F.A.O Mrs S Leeson, Planning Officer RE: F40/12

Change of use from Offices to Residential at church House, 94 Felpham Road felpham

I object to the above Planning Application on the following grounds:

Drawing
**EXISTING & PROPOSED
FLOOR PLANS**

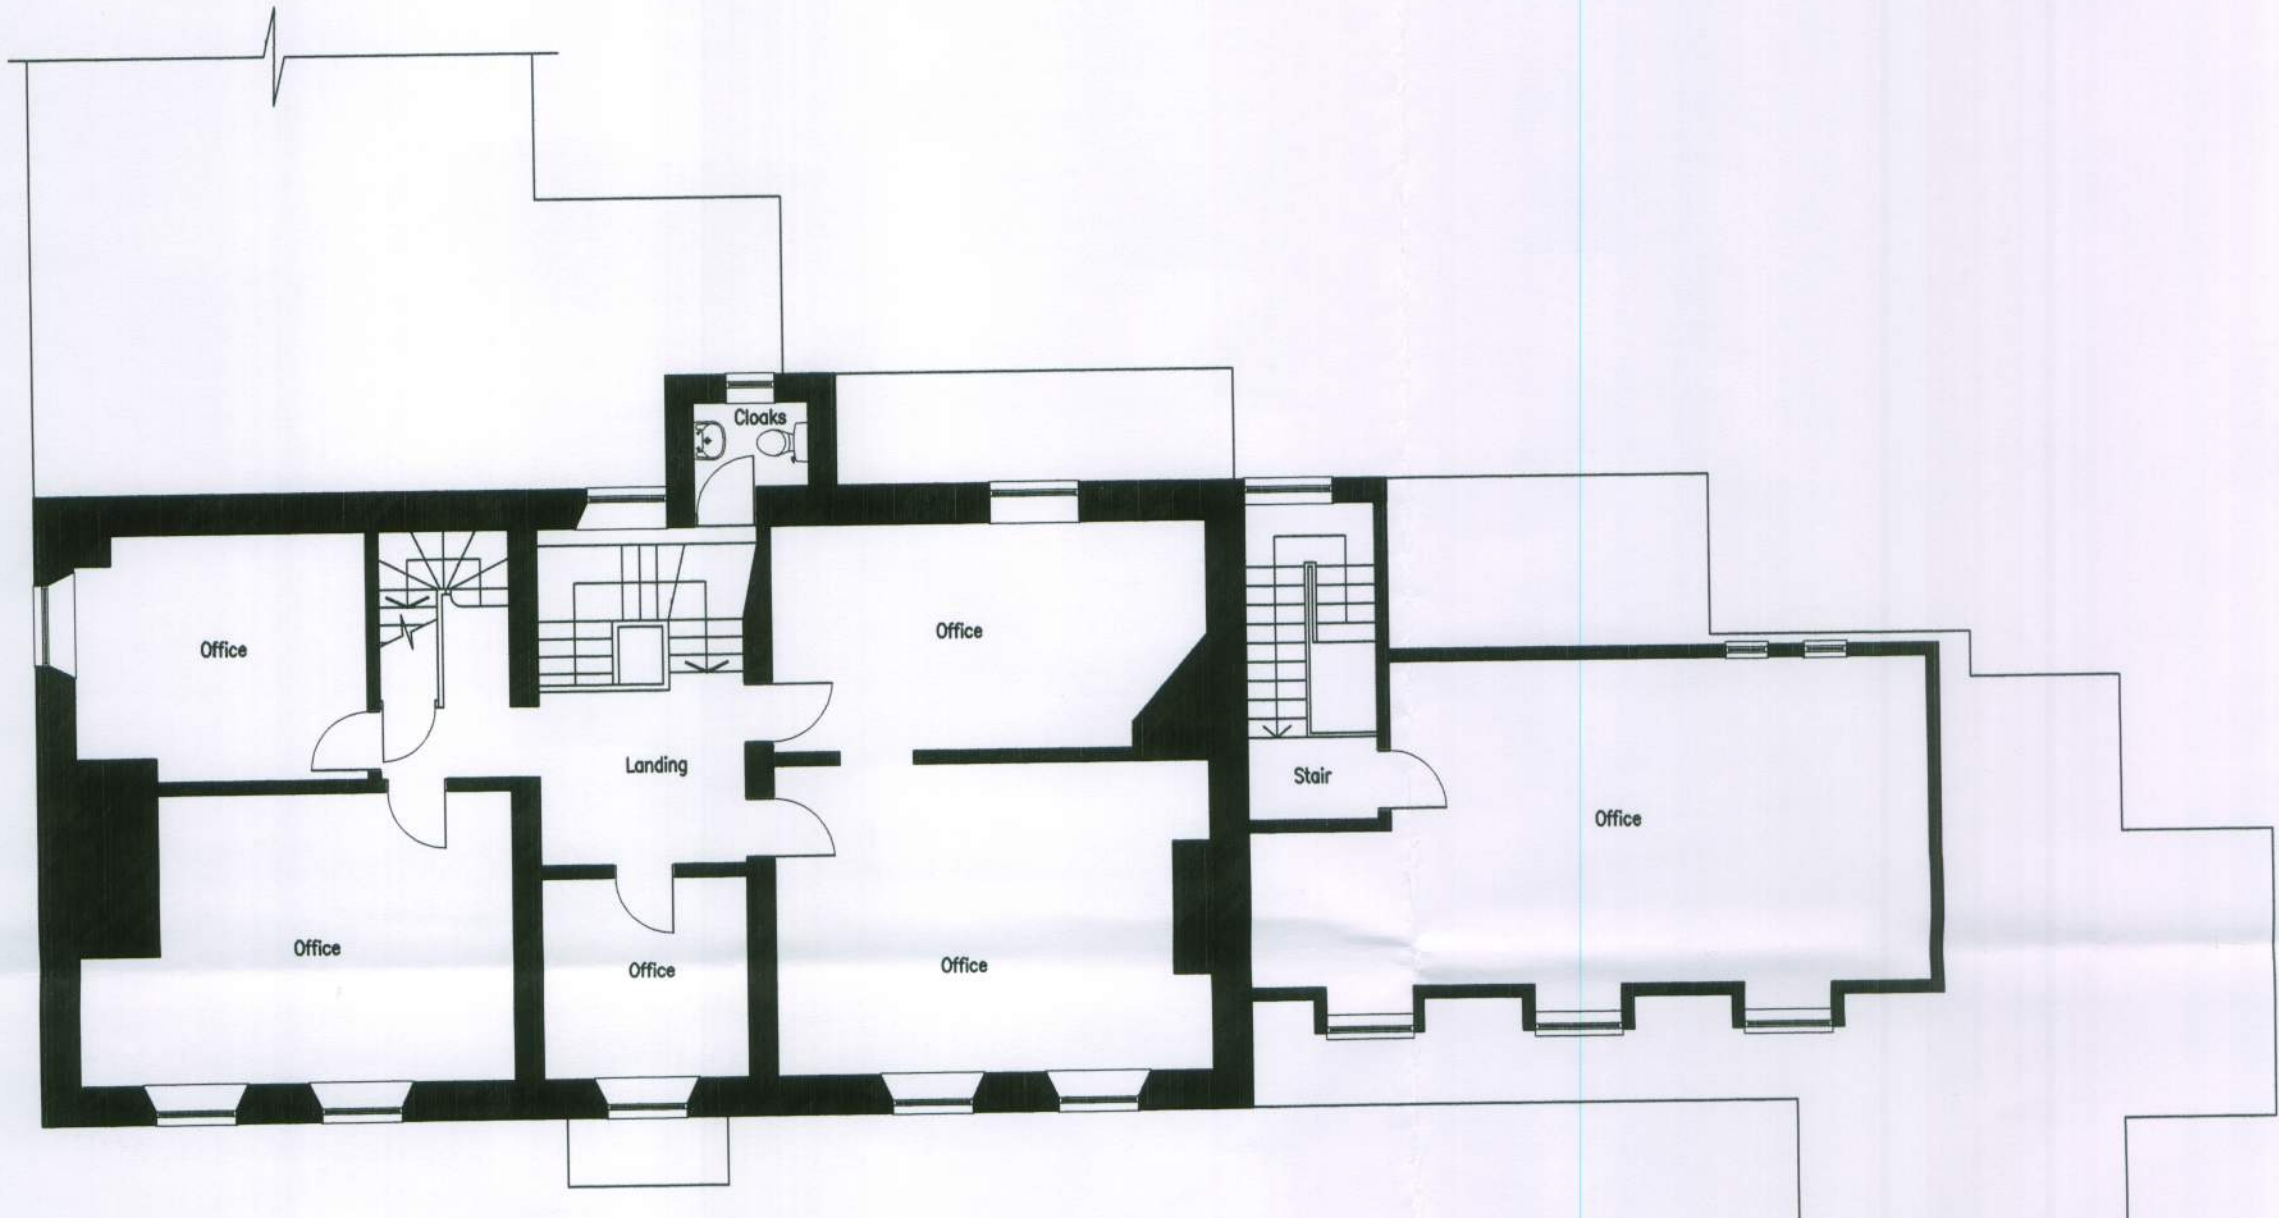
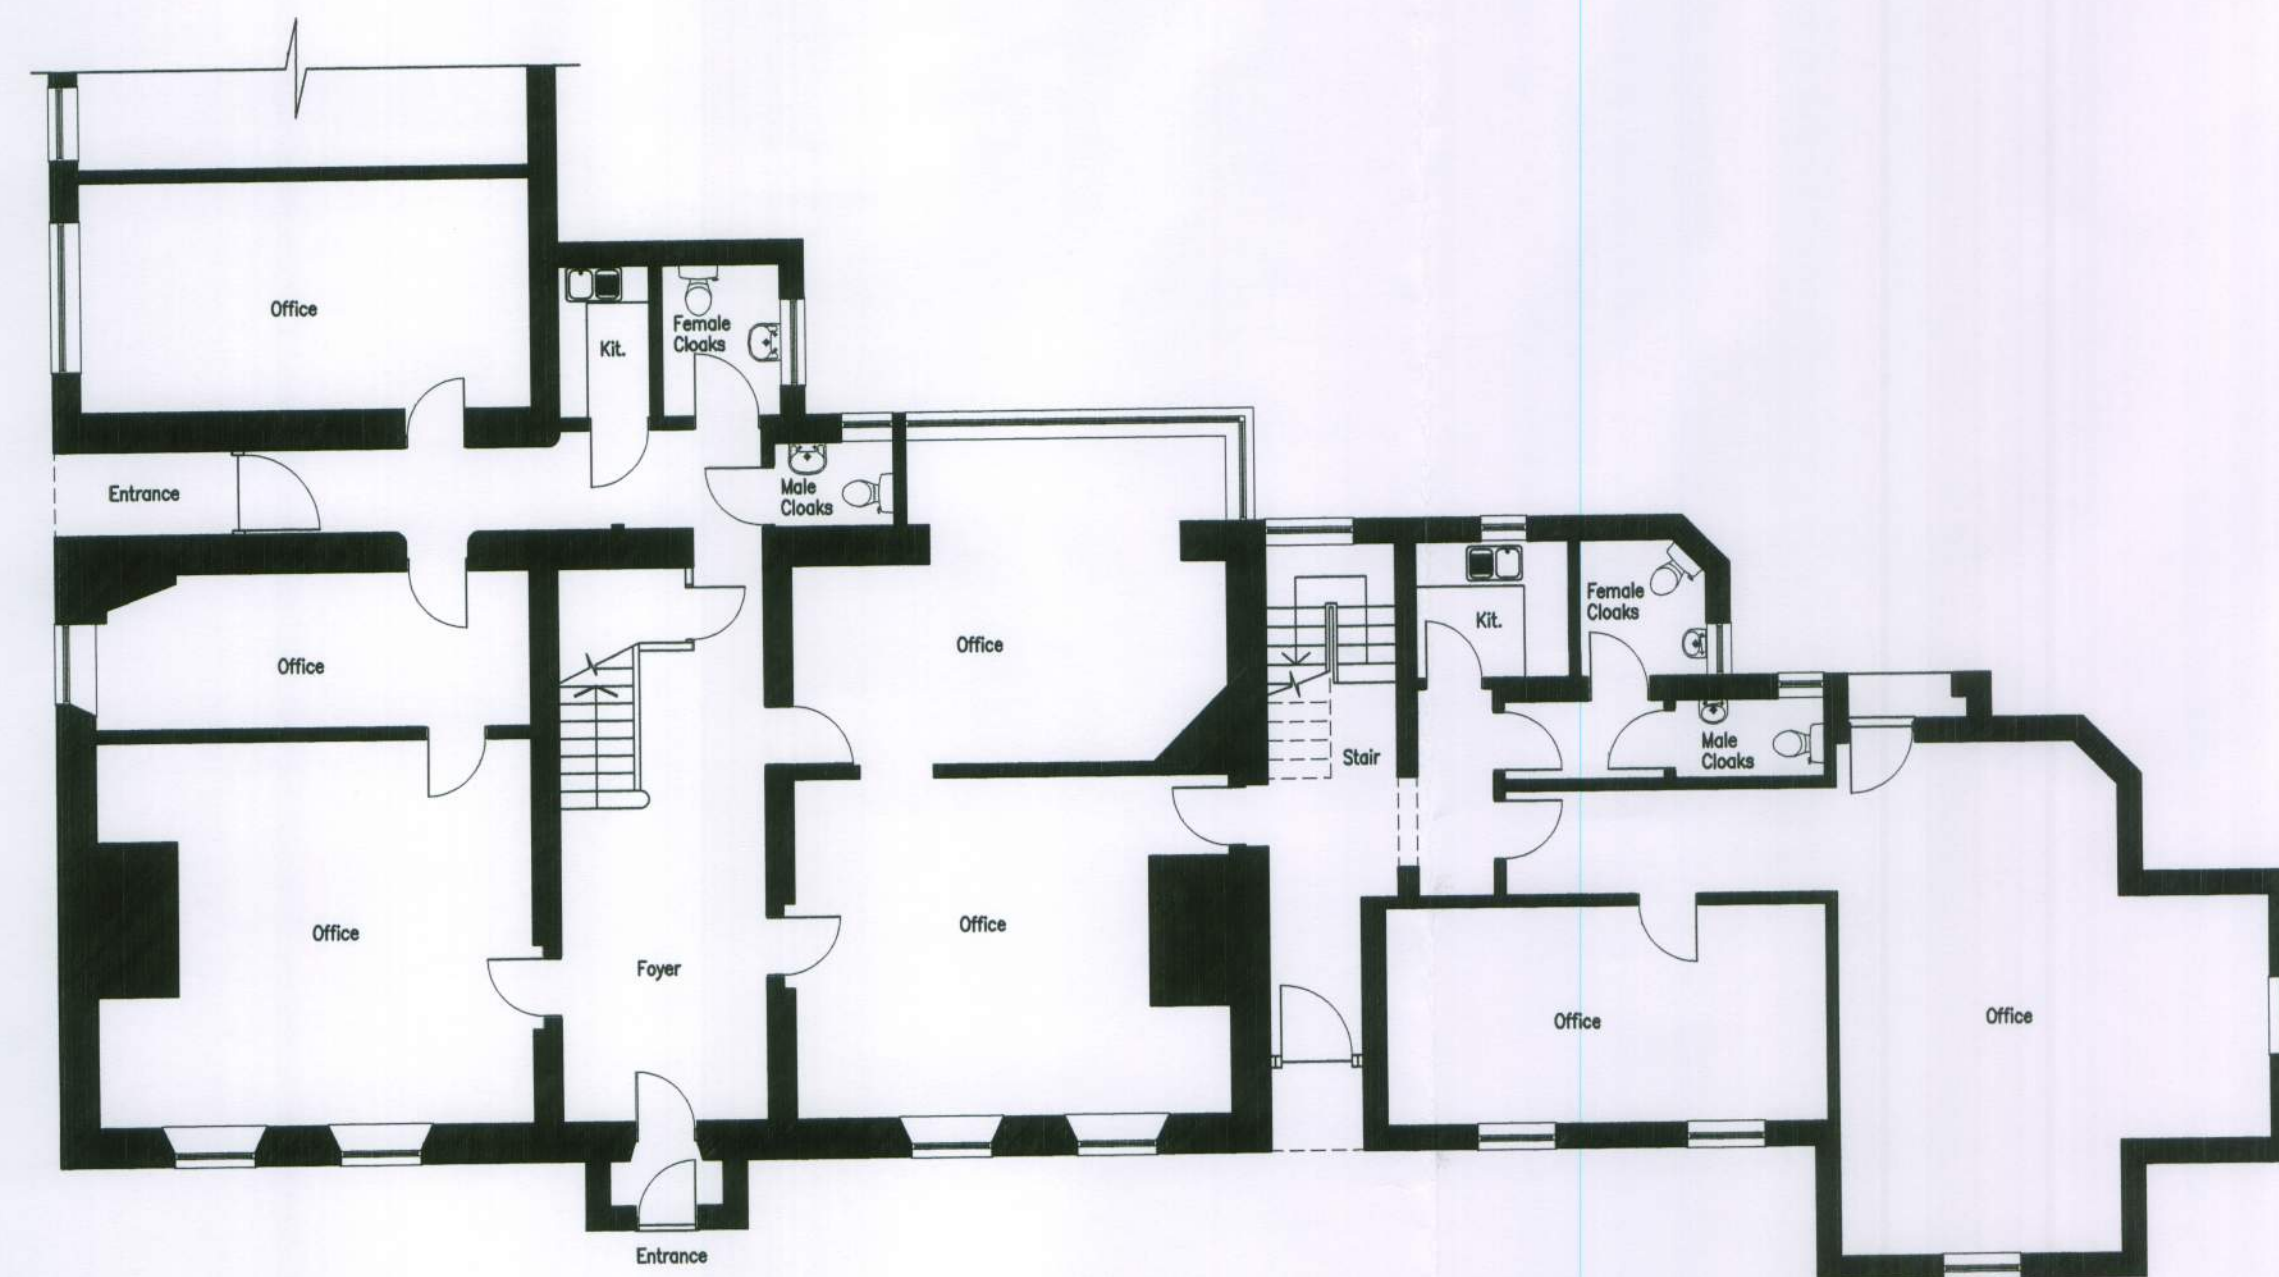
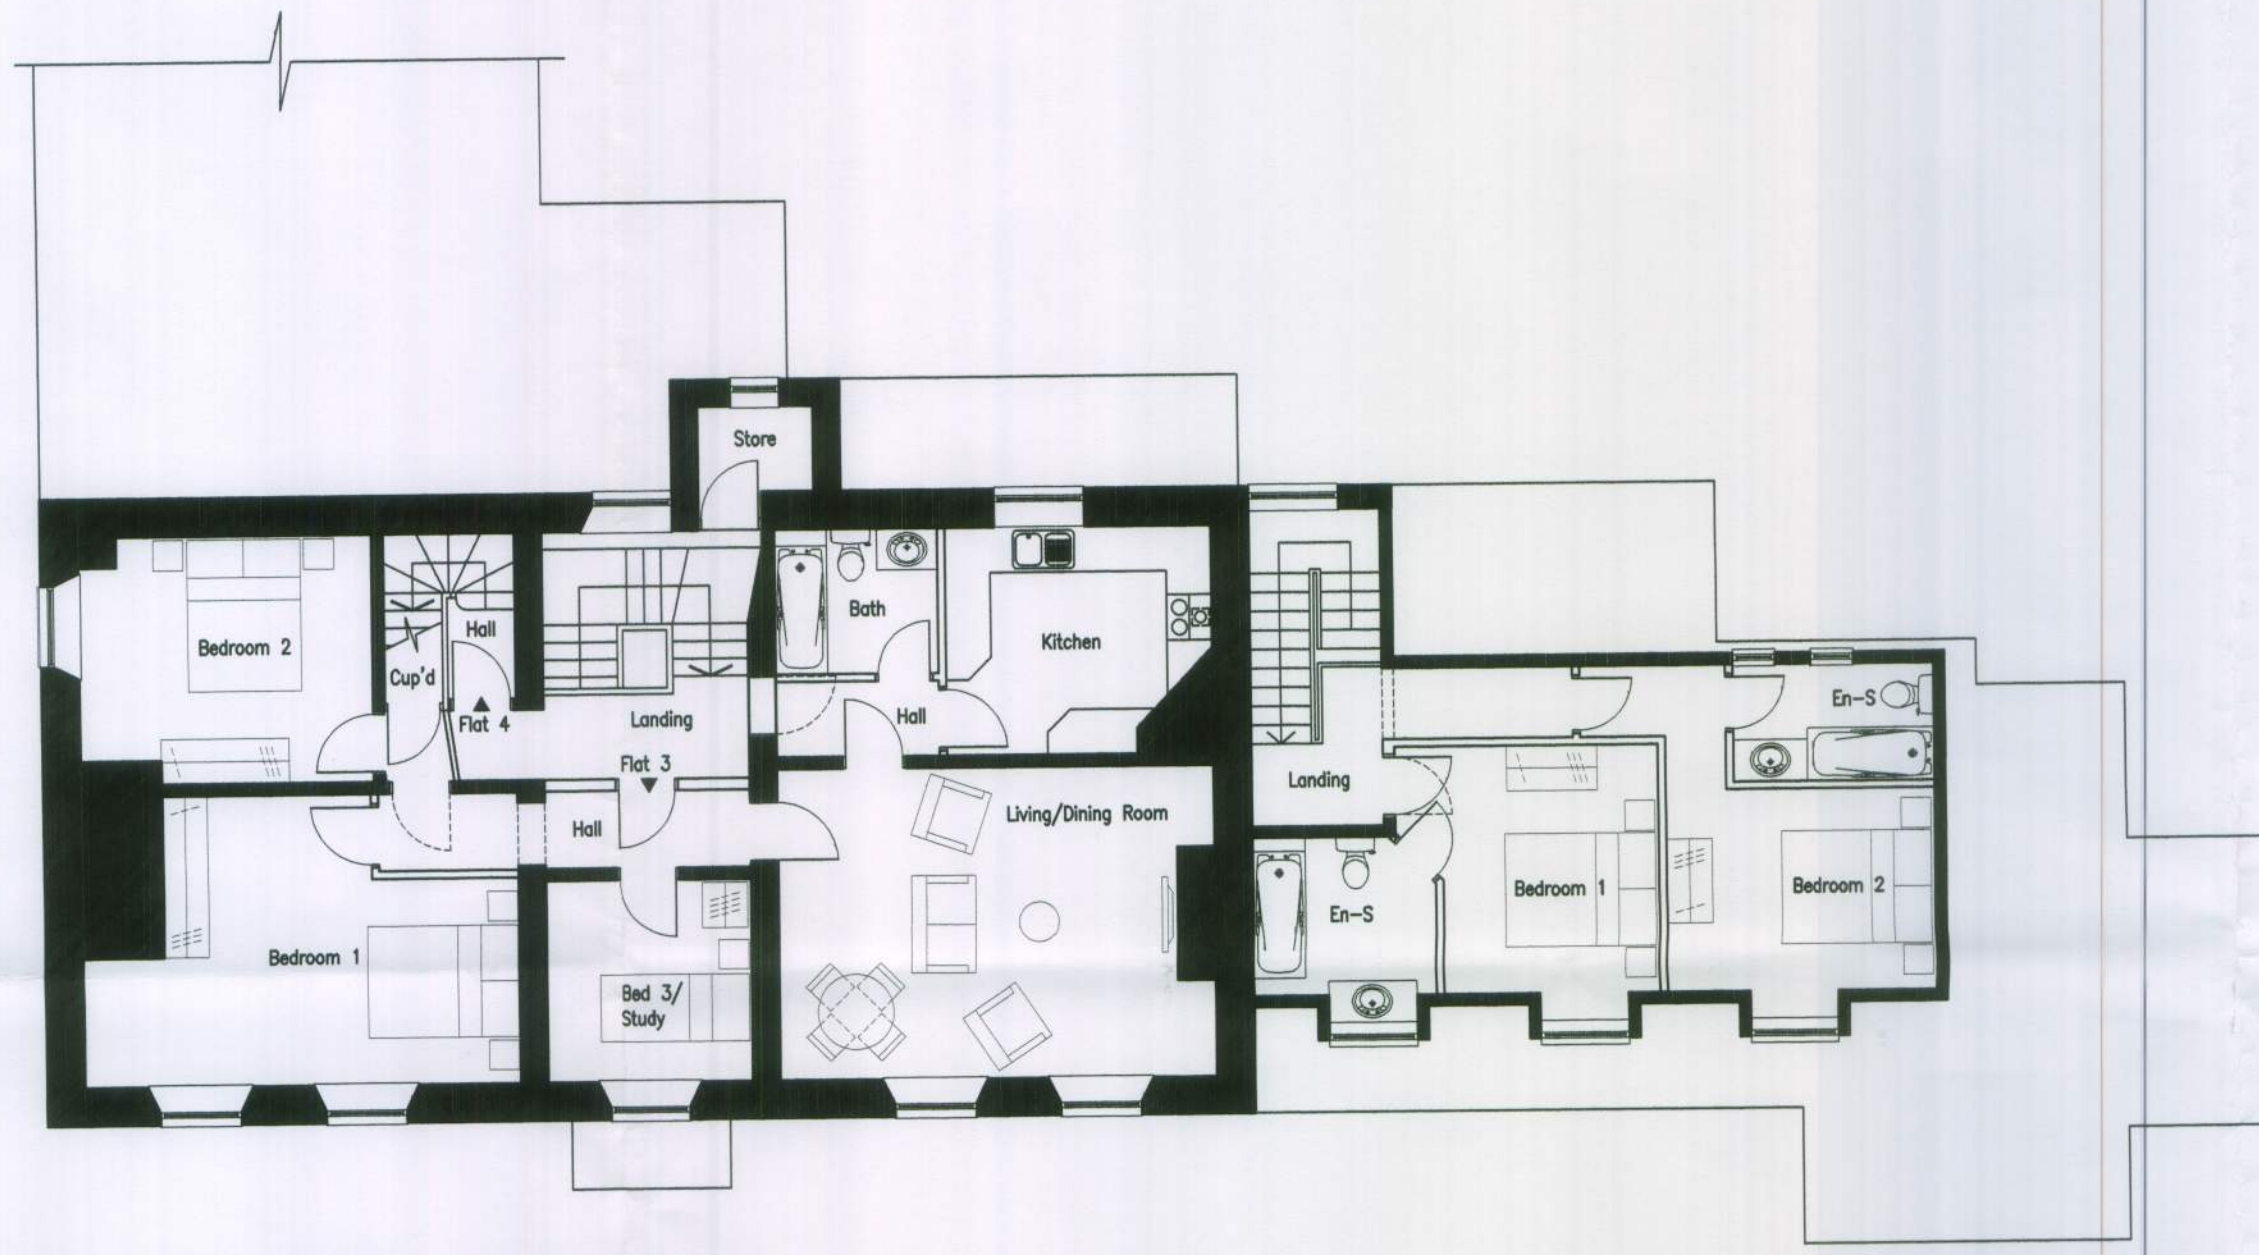
The plans at the moment are very sketchy but the proposed change to Church House would mean very over populated accommodation, where are the fire escapes, bin and recycling stores, outside space for washing etc, the parking is an issue, where would the visitors parking be, making a safe access in and out of Church House into either Limmer Lane or Felpham Road which is already a very busy and dangerous area. There would be 6 A.D.C bins and 6 Recycling bins for collection. Verdant will only collect from the boundary of Church House which places them on the pedestrian walkway

The development as proposed will devalue my property due to the extensive over development of this lovely listed building and site. For the past 46 years this building has been used as professional offices and should be kept as such, if there were to be a change of use to Residential there is the potential for bedsits and further inappropriate development to go ahead. The proposed dormer windows at the front of the building would alter the proportional balance of the Building.
